Your Ref: OWQC7346
Our Ref: A/129/15/PL
Please ask for:
Mrs A Gardner

Replacement of glass roof to existing covered courtyard, removal of valley to rear, removal of chimney stack to rear, insertion of first floor window to rear, re-roofing of main roof & repair of existing boundary wall. This application affects the character & appearance of the Angmering Conservation Area.

Blaber House The Square Angmering

Thank you for your internet comments made on 6th November 2015 which has been recorded as **'an objection'** with the comments as follows:

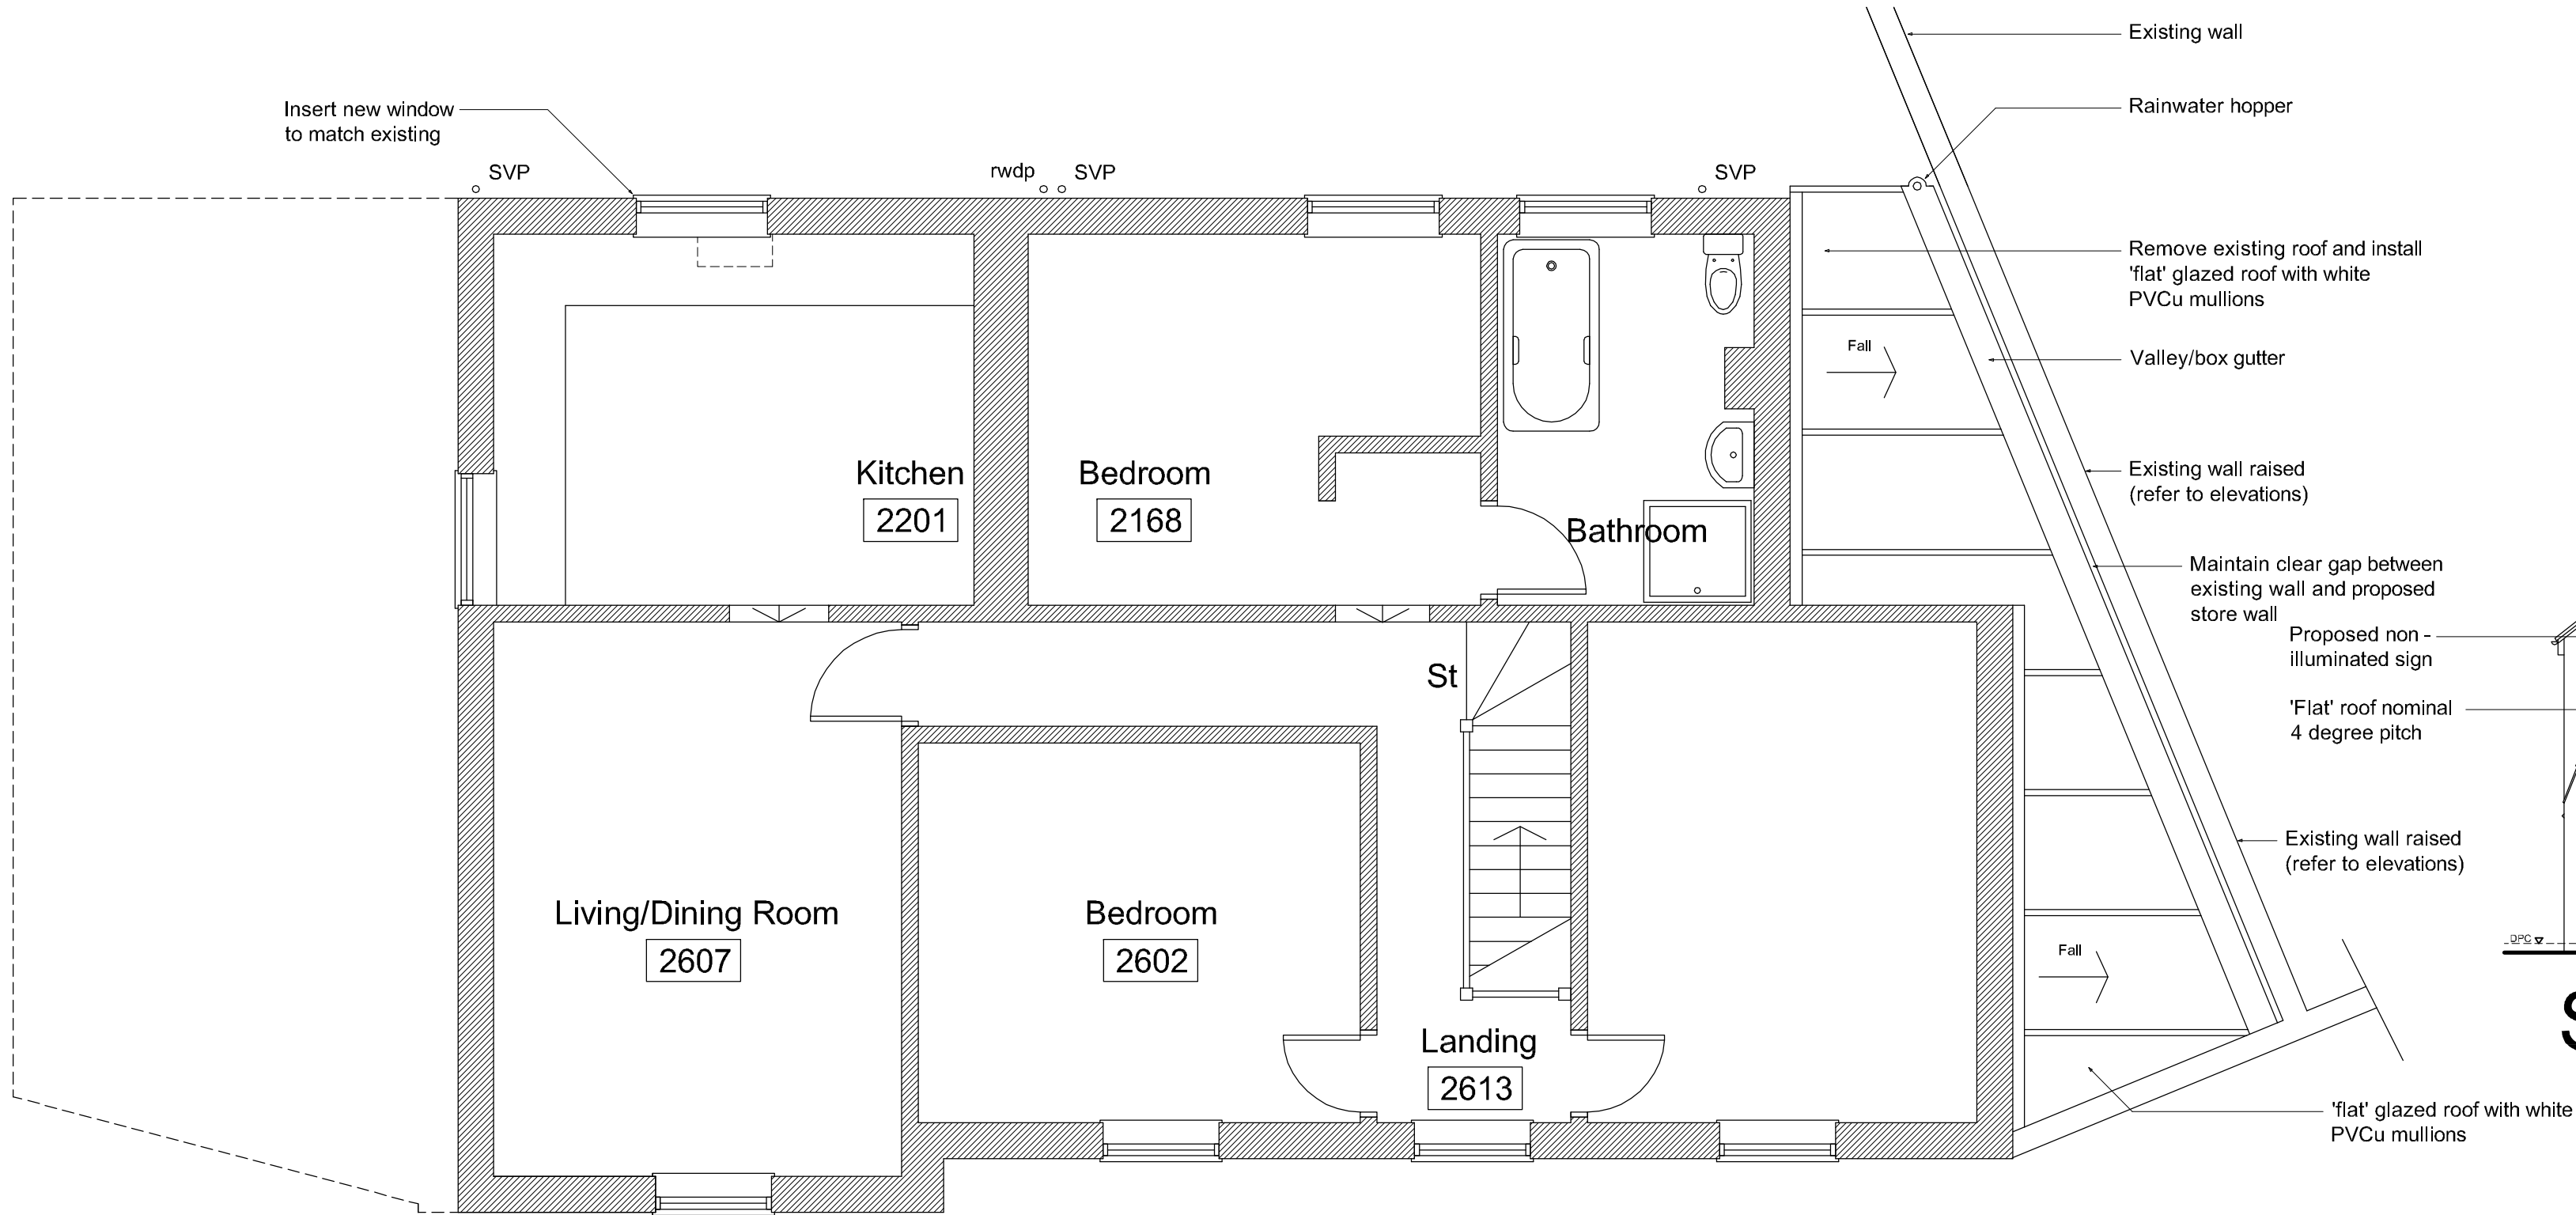
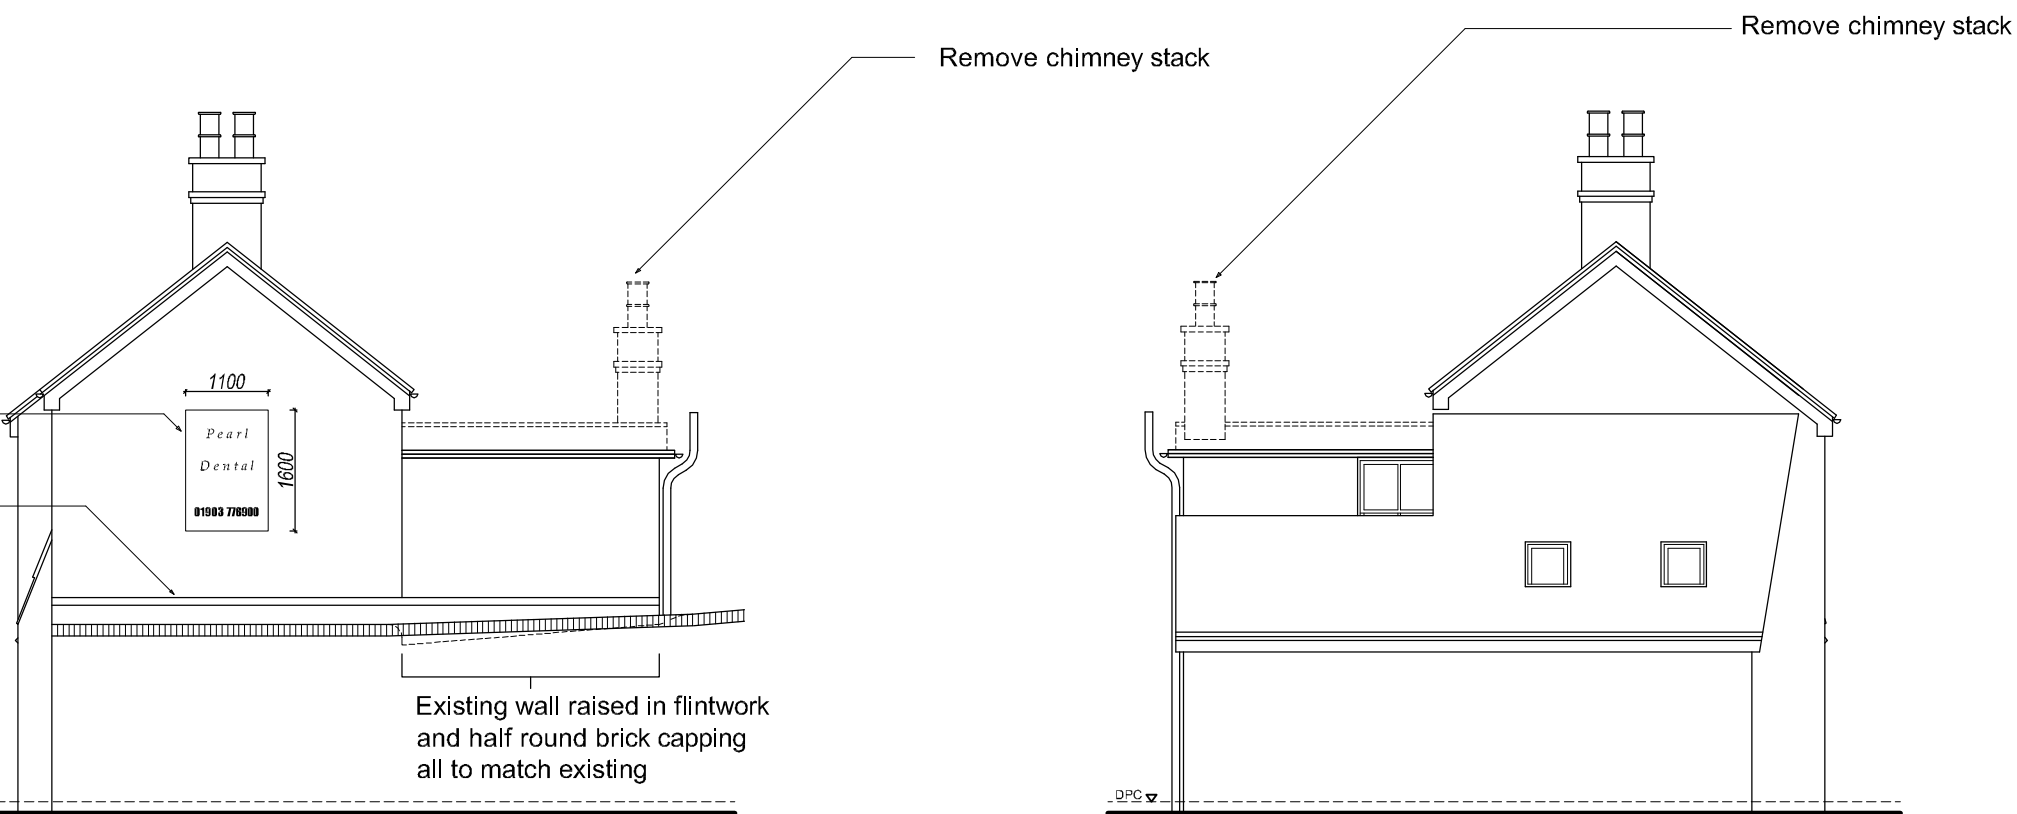
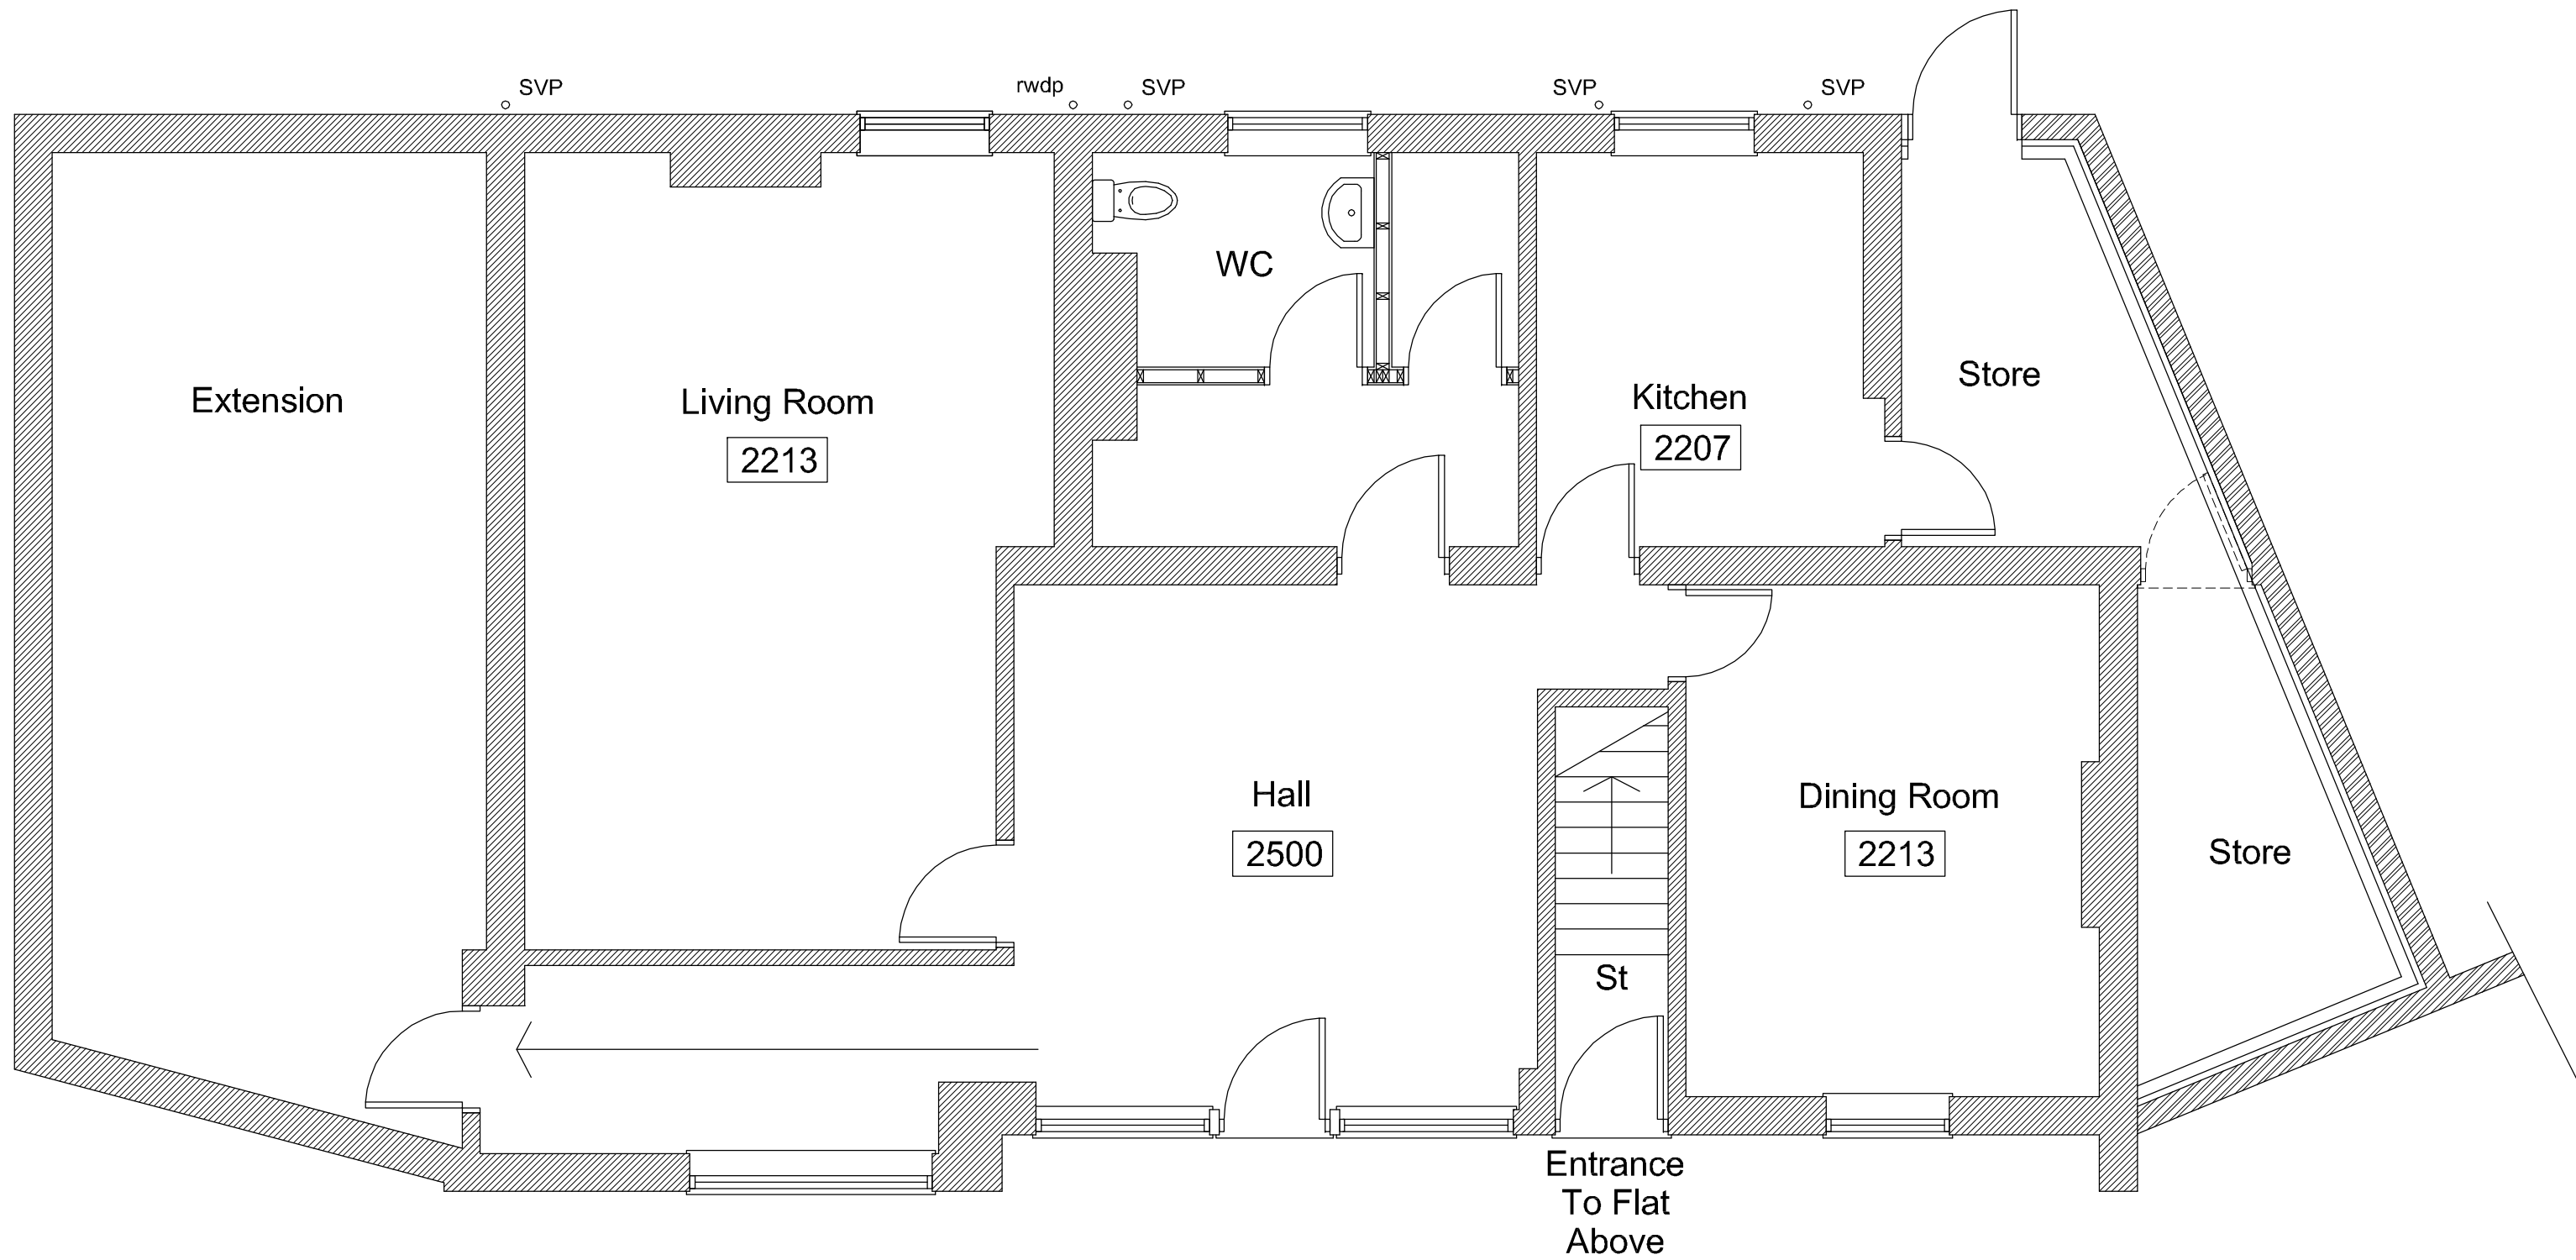
*Considered at Planning, Conservation & Development Committee Meeting 03/11/2015.
Note and agree with the grounds for objection given by the Conservation Area Advisory Committee. The proposed works would be significantly overbearing on properties in Church Road. The proposed additional signage appears excessive in size.*
